Huntlee New Town Residential Subdivision Stage 1 (MP 10_0137 MOD 11)

The Biodiversity and Conservation Division (BCD) of the Department of Planning Industry and Environment (the Department) has reviewed the submission for Modification 11 'Section 4.55(1a) Modification Application MP_10_0137 (Mod 11) Huntlee New Town, Branxton' prepared by Ethos Urban, and dated 7 November 2019. BCD understands Mod 11 involves the creation of one additional residential lot within residential Stage 16 (R16) as a result of the subdivision of superlot 222, and one additional Town Centre commercial lot within TC1, delays in the timing for the road upgrade, minor road and lot boundary alignment amendments, and a request to change conditions of consent.

BCD's detailed comments

FIGURE 4E

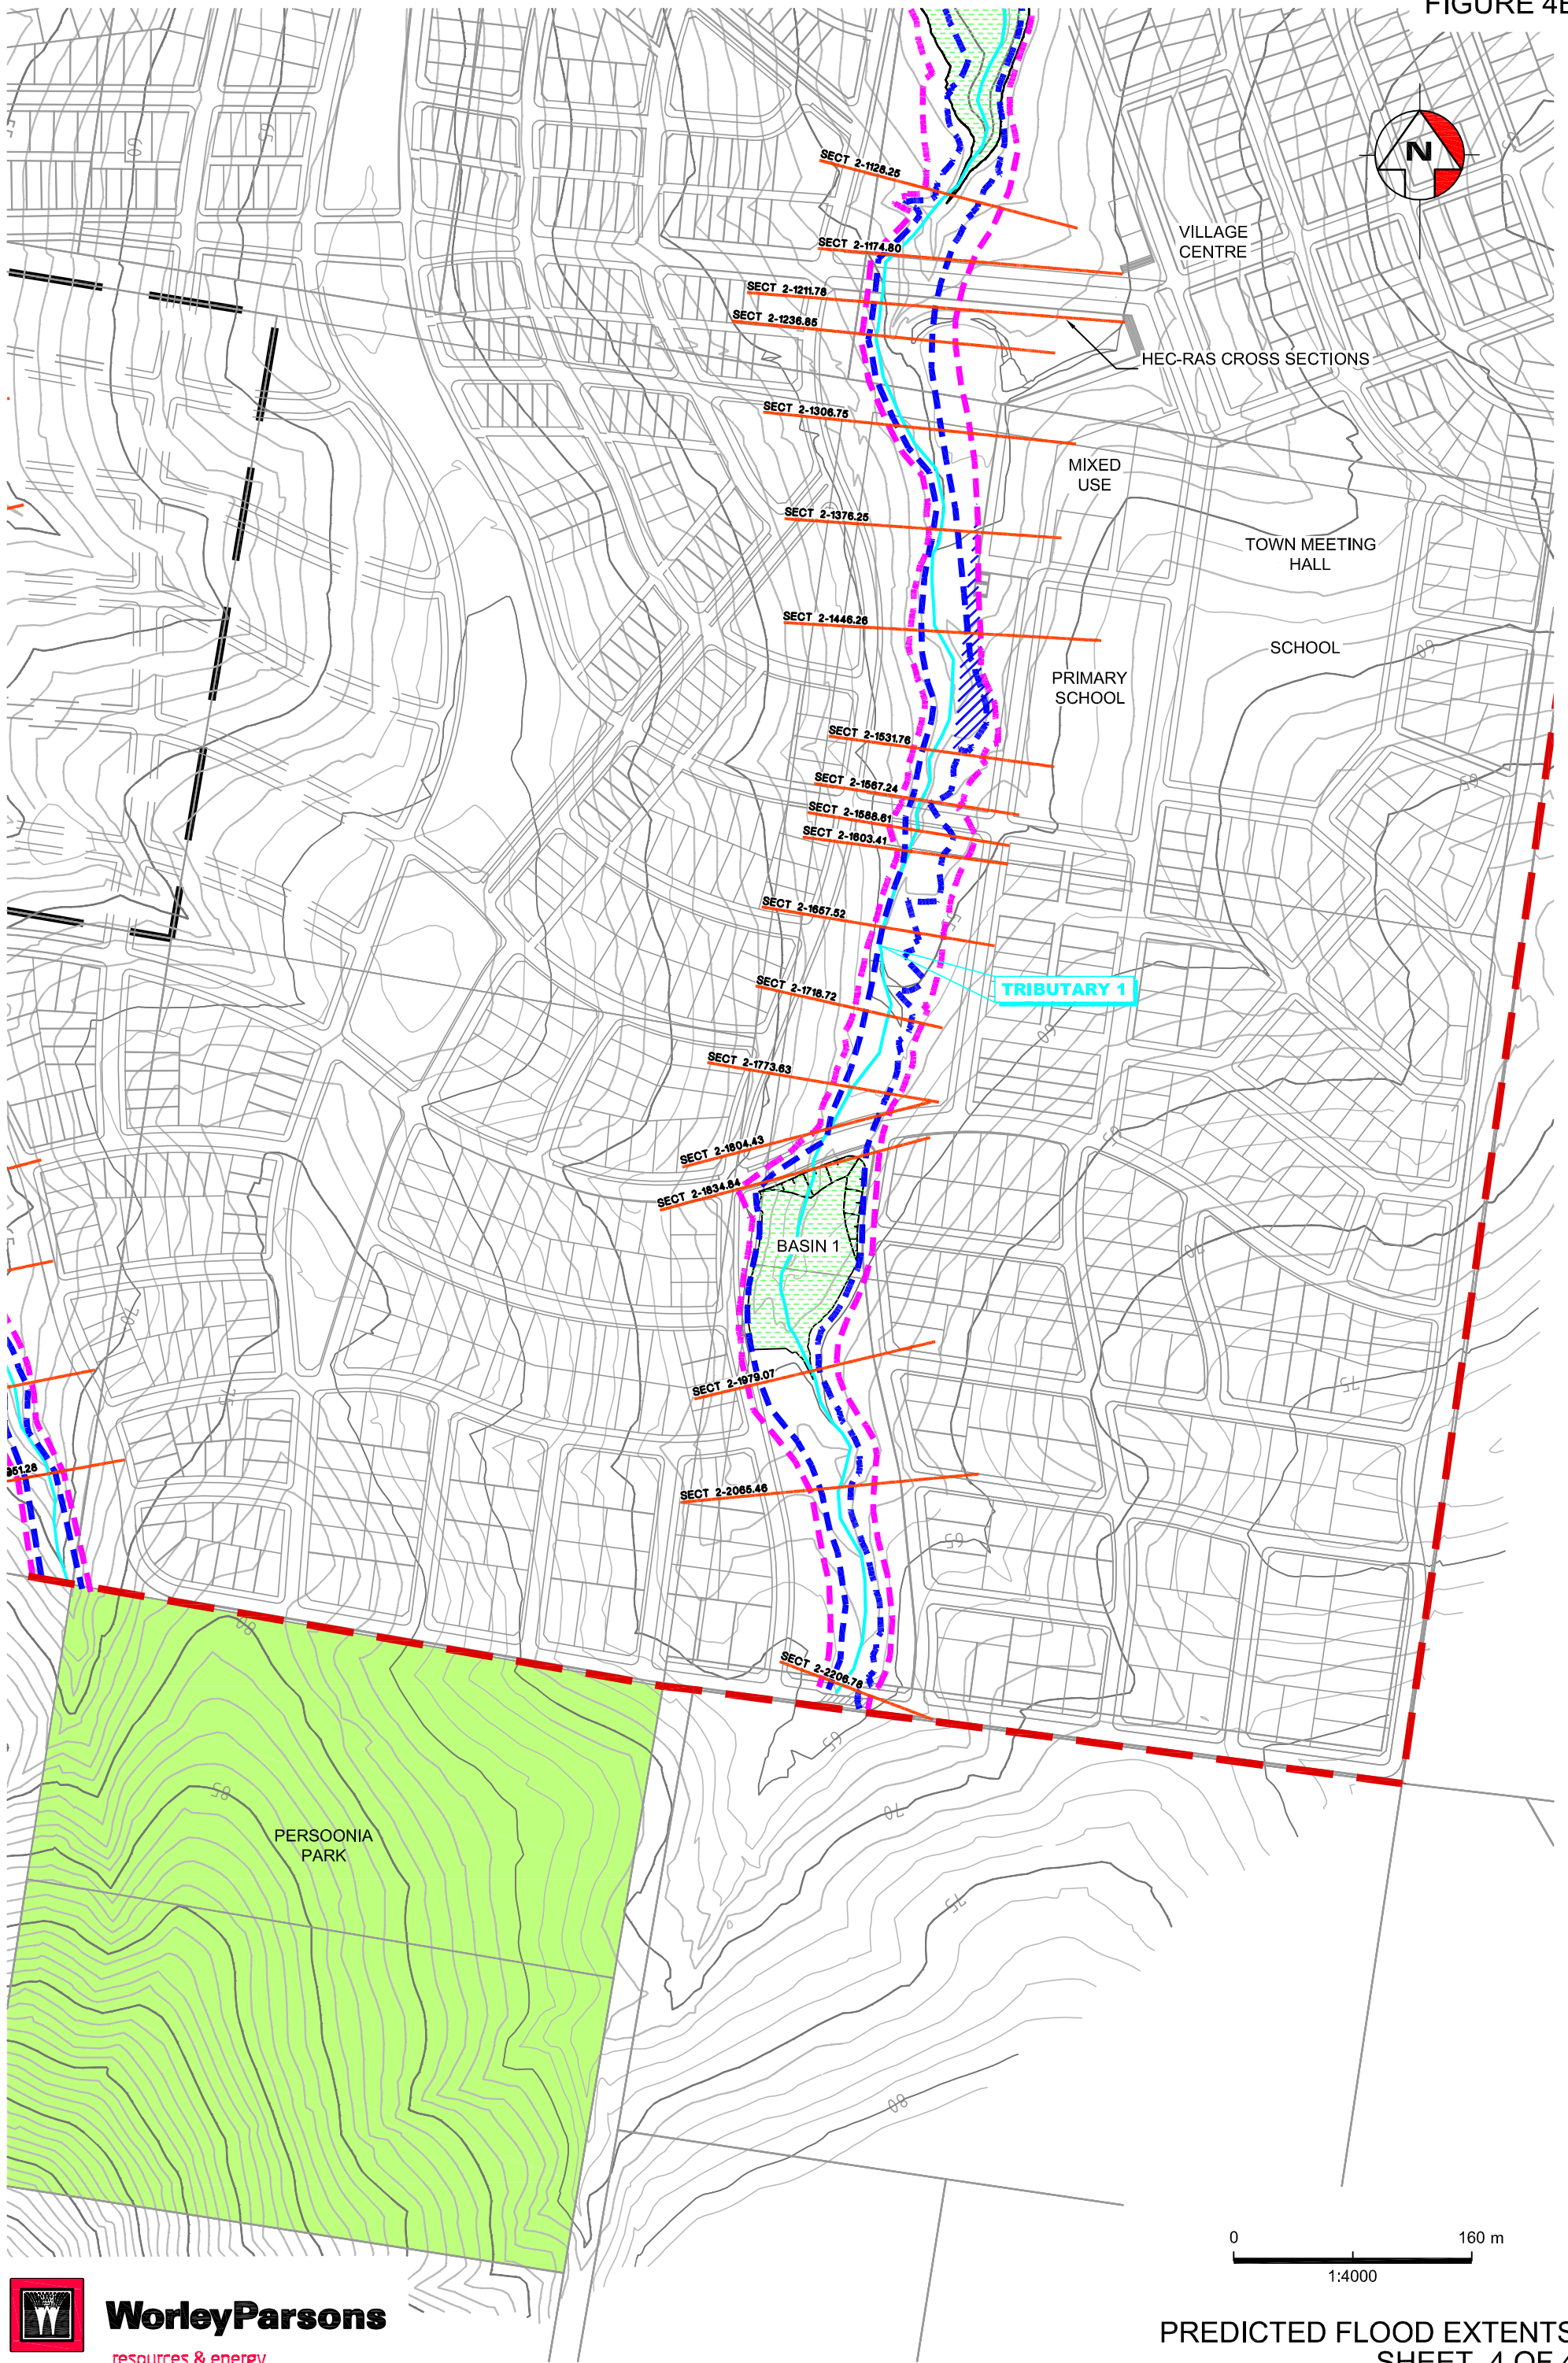
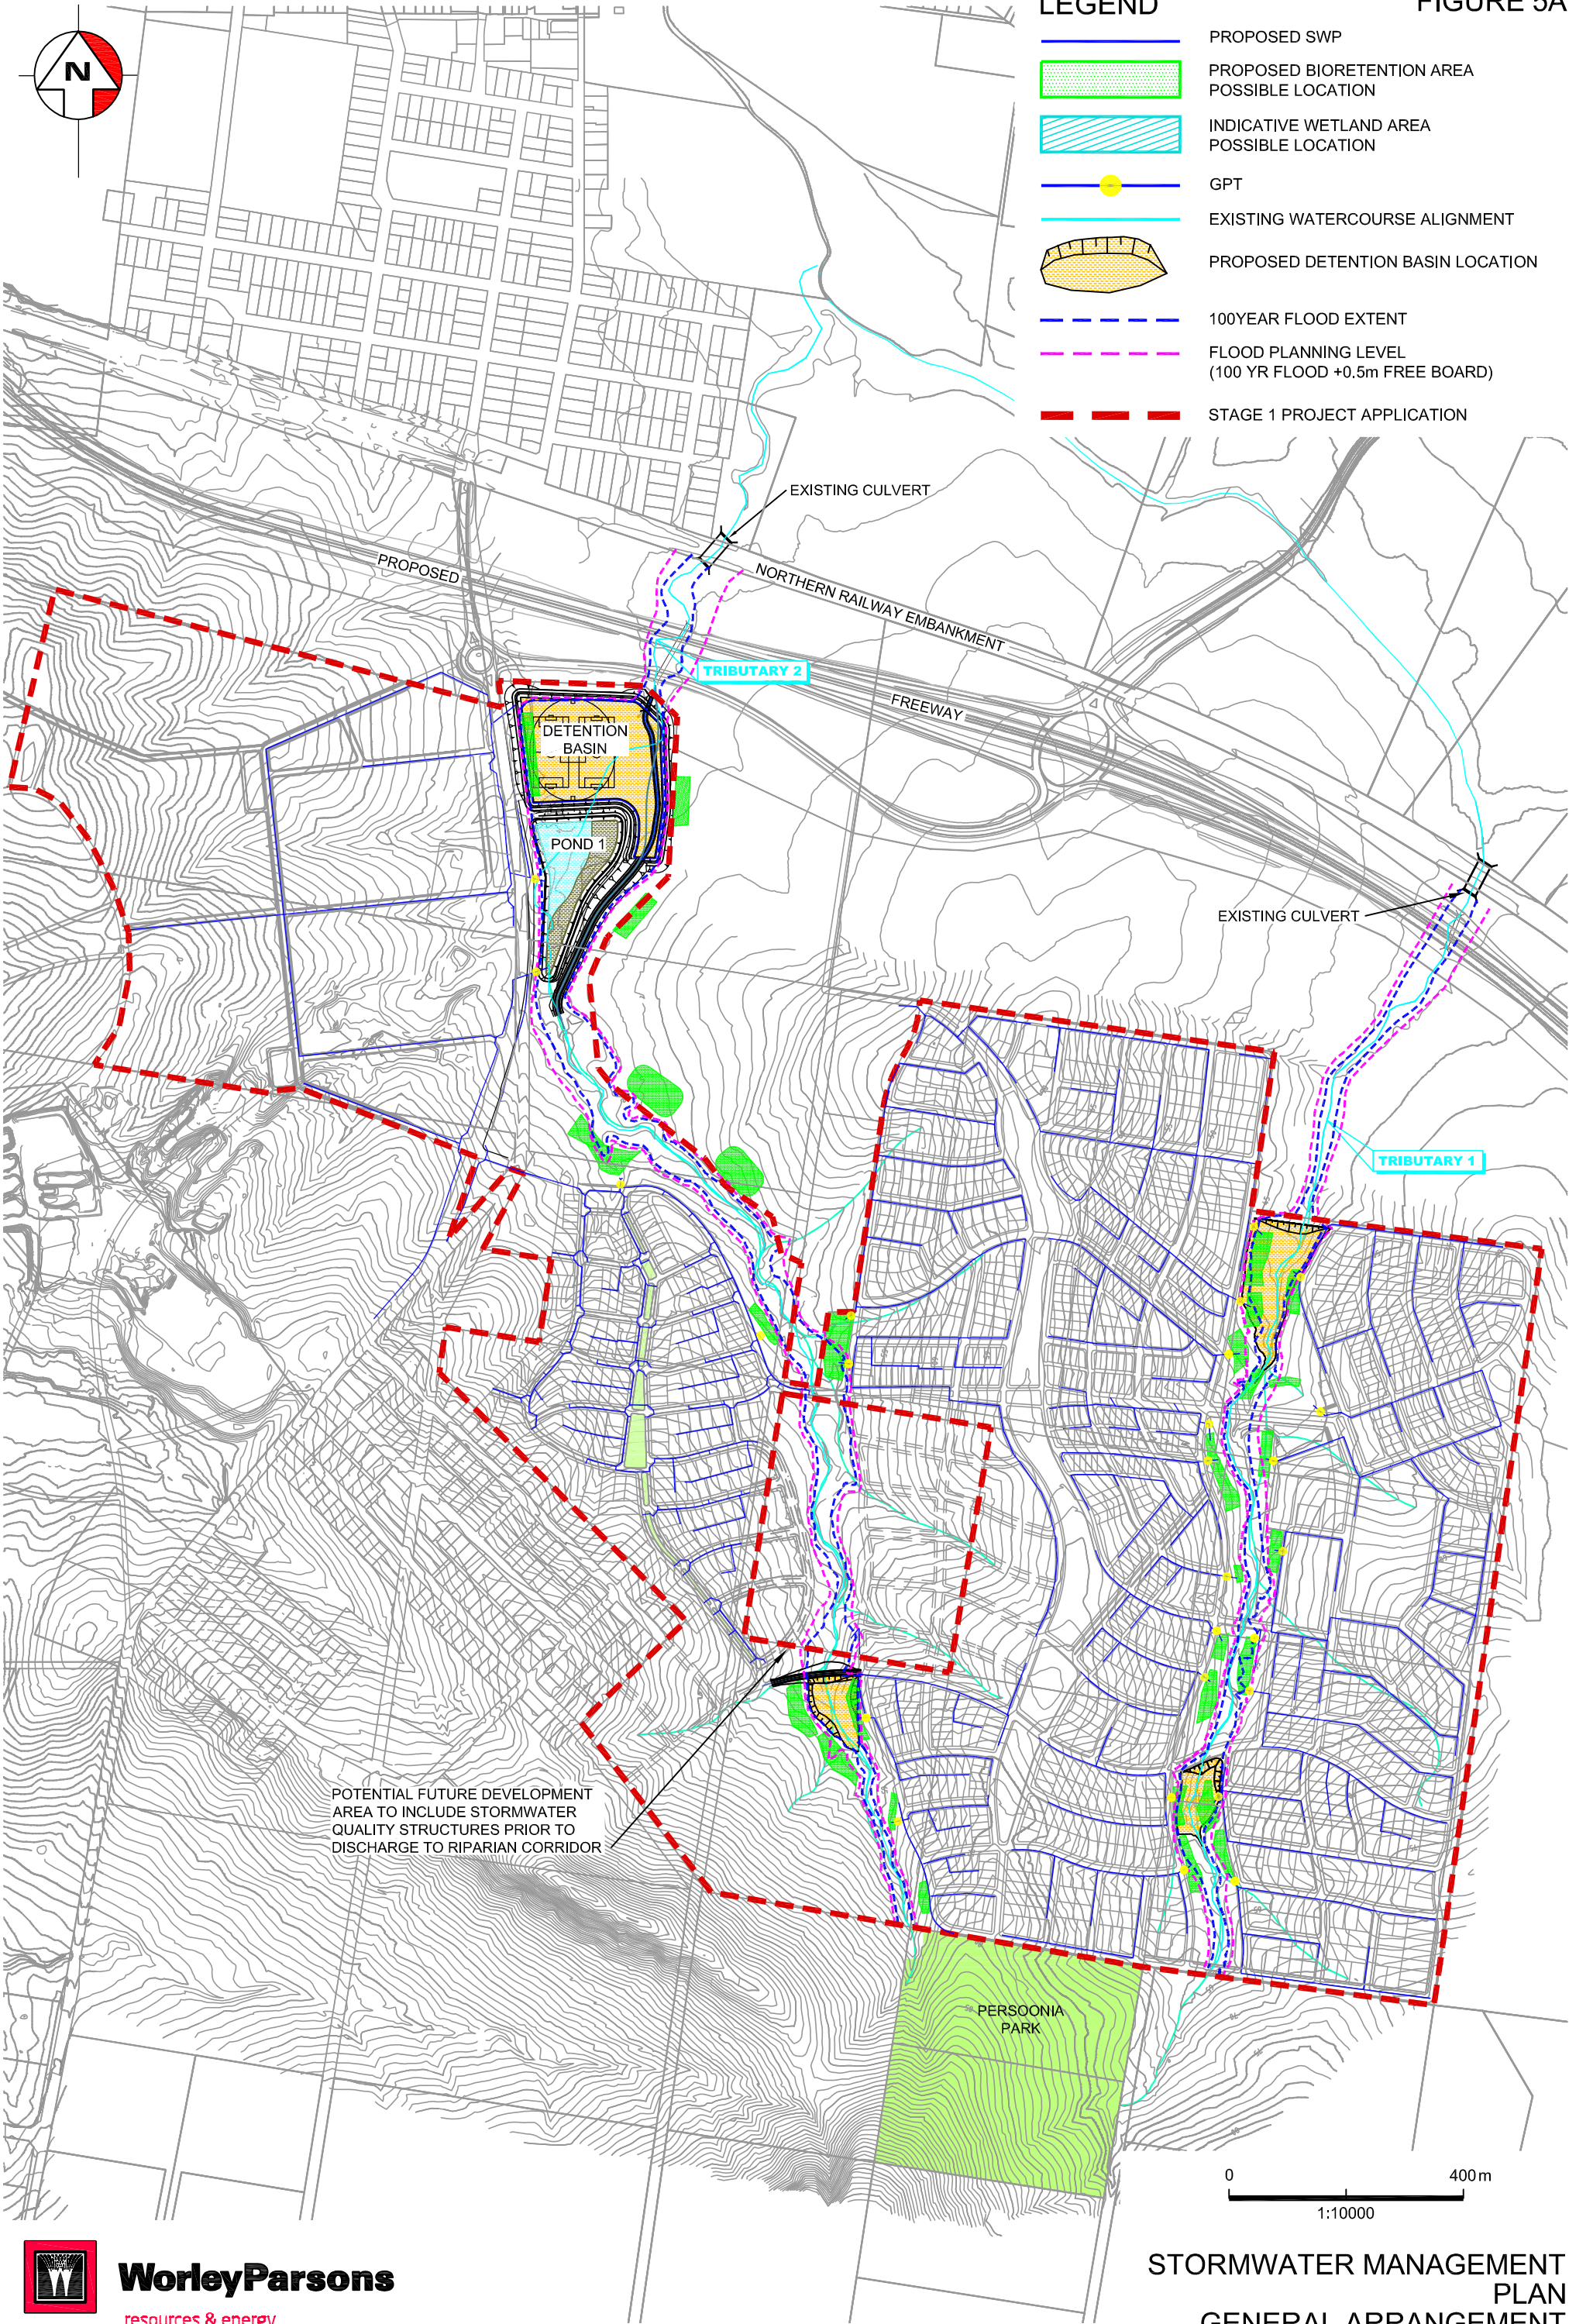
Attachment E, Huntlee Stage 1 Constraints on Amended lots shows the flood extent on the proposed lots. This plan is of too small a scale to determine if encroachment into the flood extent has occurred. Mod 11 presents the Worley Parsons flood map in support of the changes. The flood map is for the original subdivision and the flood extent shown on Attachment E differs from that on the Worley Parsons mapping.

Flood mapping needs to be updated to reflect the revised on-site detention structures, lot layout and flood extent. Mapping provided is to overlay flood extent on the proposed lot layout at adequate scale to enable impact to be assessed.
